# COMMENTS:

ON 9-9-10 - MET NEEL FLOYD ON Lot 99 About Layout to Septic System for this lot. OT was present  
NEEL proposed a layout I TOLD him to submit Layout, that we under circumstances Agreed that new layout  
ON 9-10-10 - THAT morning I CAME TO WORK Layout on my desk was sort of contrary to discussion  
that we all HAD, I TOLD NEEL THAT there was a bad spot in center of BACKLARD.

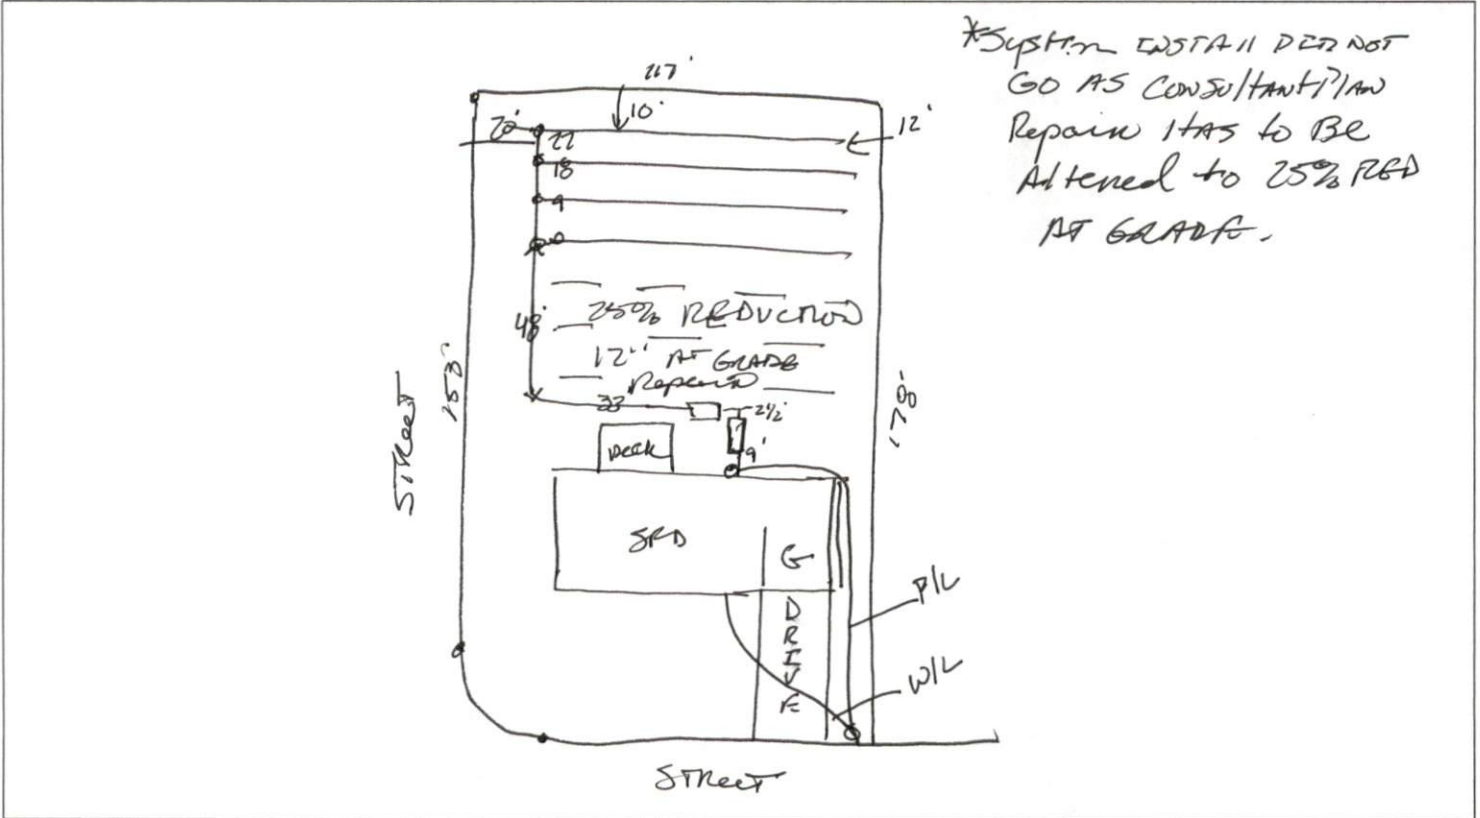
IF HE DIDNT see IT then I would agree on Layout. - The Layout basically dis-regarded  
what I HAD TOLD NEEL About Repair Area in BACKLARD. I went OUT ON 9-10-10

DOG A HOLE IN THE AREA discussed and it was out AT 22" I TO  
CALL OT TO come BACK OUT TO confirm. HE DID BUT HIS OPINION WAS THAT  
IT WAS 24" TO 26" MAX SOIL DEPTH so he said give the report to NEEL Floyd

JUST make him amend his new proposal to AT GRADE Repair, CALL N.F.  
to re-submit Report AS discussed. Above Con permit issue -

HAD TO GO WITH OT professional opinion on repair.

System does NOT GET ESTABLISHED EXACTLY AS permitted for consultant's layout  
DETAILS when in process discussed NOT being Tr. Repair Change etc.
